Recommendation Report for Works to Tree(s) on trees subject to a Tree Preservation Order (TPO)

REF NO: EG/5/19/T

LOCATION: 111 Barnham Road
Barnham
PO22 0EQ

PROPOSAL: Raise crown to 2.4m to 1 No. Monterey Pine tree

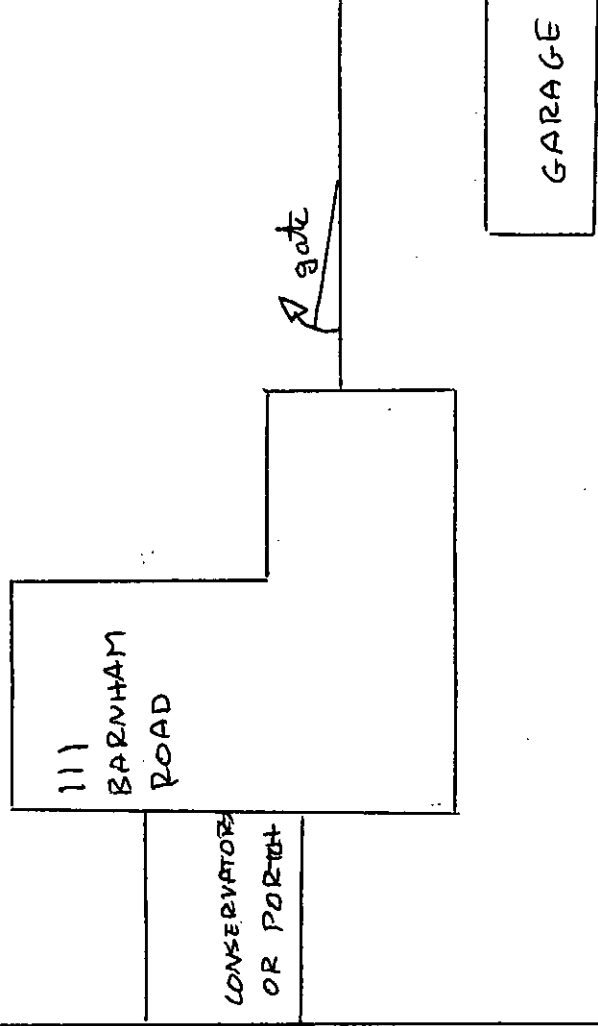
- The applicant is proposing the removal of a single branch that risks direct damage to their boundary fence line. The offending branch is small (<100mm diameter), discreetly located within the adjacent understorey and is dead.
- The 'live' crown is in excess of 2.4m height, and so there seems to be no proposal for the removal of

any foliage-bearing limbs/branches.

- the applicant is proposing the removal of any 'live' growth (usual when crown lifting is specified) then this has not been made explicit. The large and obvious low limb tending south from the tree should be retained but if it is their intention to remove it we would need them to make that clear.

- The offending branch is small (<100m diameter), discreetly located within the adjacent understorey and is dead. As such, it is an exception from the normal application process and can be removed (as with all and any dead branches) without requiring permission from the local planning authority.

- If the applicant advises that they intend to remove the large low limb then I would not raise an objection to such work, but a new application will be required and only then could consent be given subject to an appropriate condition being applied (which I can provide).

· I recommend the applicant is advised of the contents of this report and informed that they can proceed with the removal of any dead branches without further recourse to this authority.
